Your Ref: SSD 10313 MOD 1

26 August 2021

FAIRFIELD COUNCIL COMMENTS P2G FACILITY – STATE SIGNIFICANT DEVELOPMENT (SSD) 10313 MODIFICATION 1

Figure 6 | Site access route. Blue line shows the originally proposed route in the EIS and the red line shows the revised route, as proposed in the Submissions Report (Source Submissions Report - Western Sydney Green Gas Project).

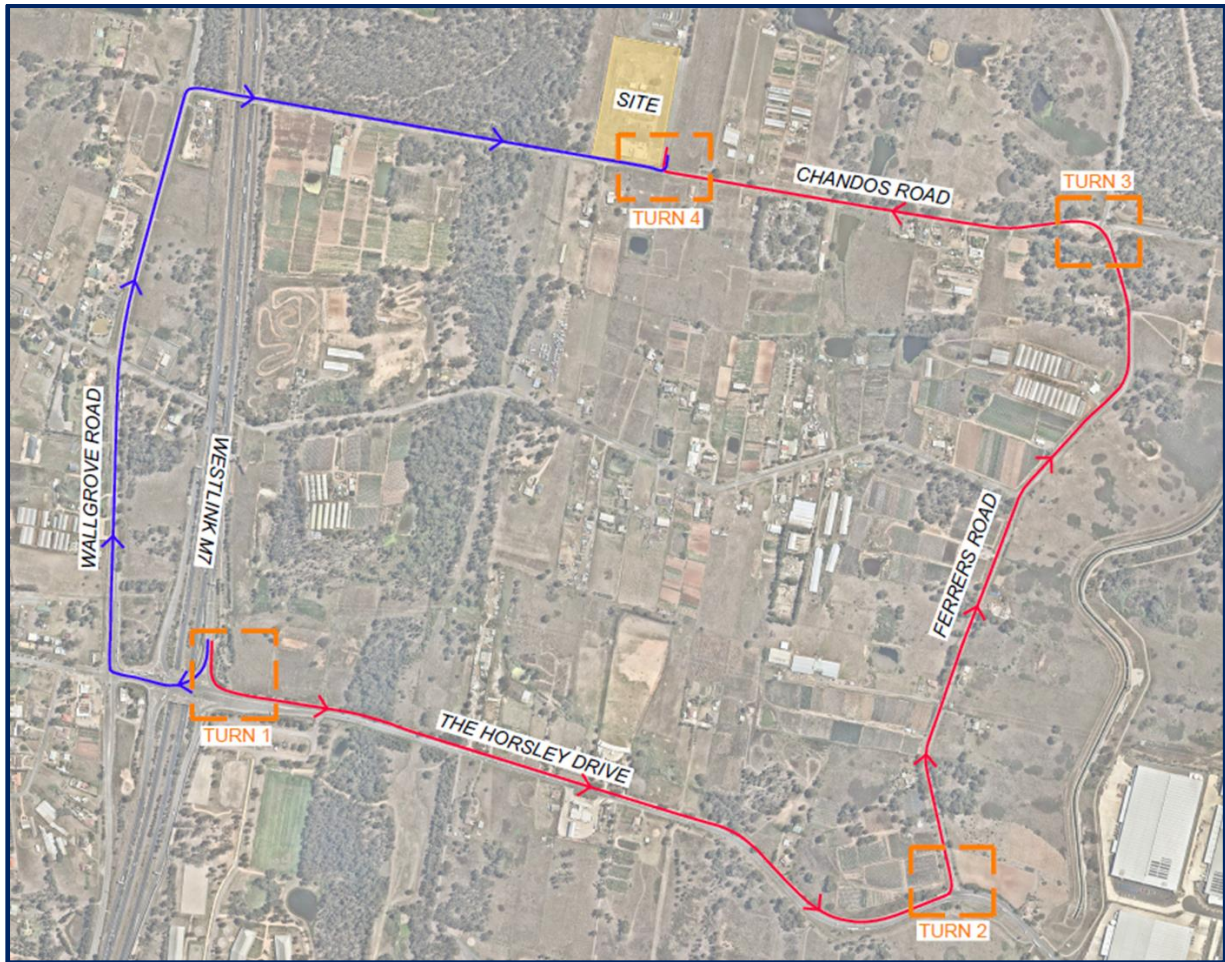
Based on swept path analysis undertaken by both the applicant and Council, 19m long articulated vehicles or large vehicles exiting the Jemena site would need to utilise the entire width of Chandos Road (along the site frontage) to make a left turn out of the driveway.

Under NSW Road Rules, vehicles are permitted to cross double unbroken lines to enter or leave the road by the shortest route. The left turn manoeuvre when exiting the site is considered a safety concern. Jemena must consider the option of widening the driveway to accommodate heavy vehicle movements and to install safety measures to minimise traffic and safety impacts on the adjoining road network.

TfNSW have also indicated the desire to reduce maintenance costs of the M7 overpass asset. Due to this the applicant has decided to utilise Chandos Road via Ferrers road. The impacts of the 19m long semi trailers (their weight/mass) on pavement and existing culverts along this route are unknown at this stage and per the comments above must be assessed prior to servicing of the site by heavy vehicles.
